REZONING PETITION 2018-034
Petitioner: Charles and Ellen Gray

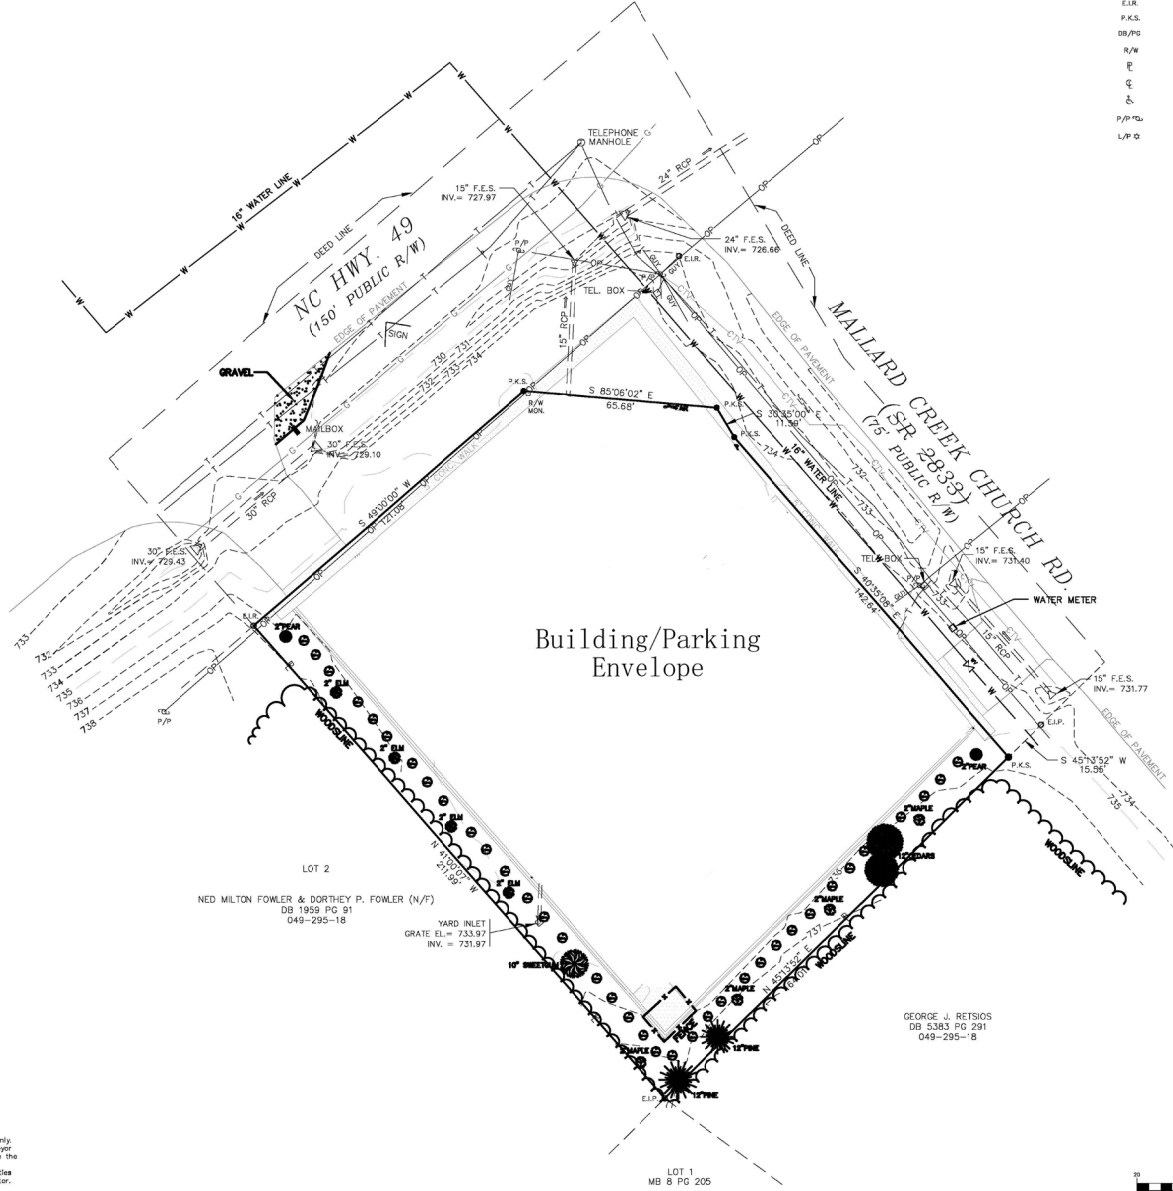
2018-034        1- For non-sprinkled buildings. Fire department must be able to reach 150' to all exterior portion of building. 2- For sprinkled buildings. Fire department must be able to reach 200' to all exterior portion of building. 3- For buildings that is equipped with a sprinkler system. A fire department connection shall be located within 200' of a fire hydrant for a NFPA 13 sprinkler system and 750' for a NFPA 13R sprinkler system. 4- Fire hydrant shall be located within 750' to the most remote point of building as truck travel for all buildings.
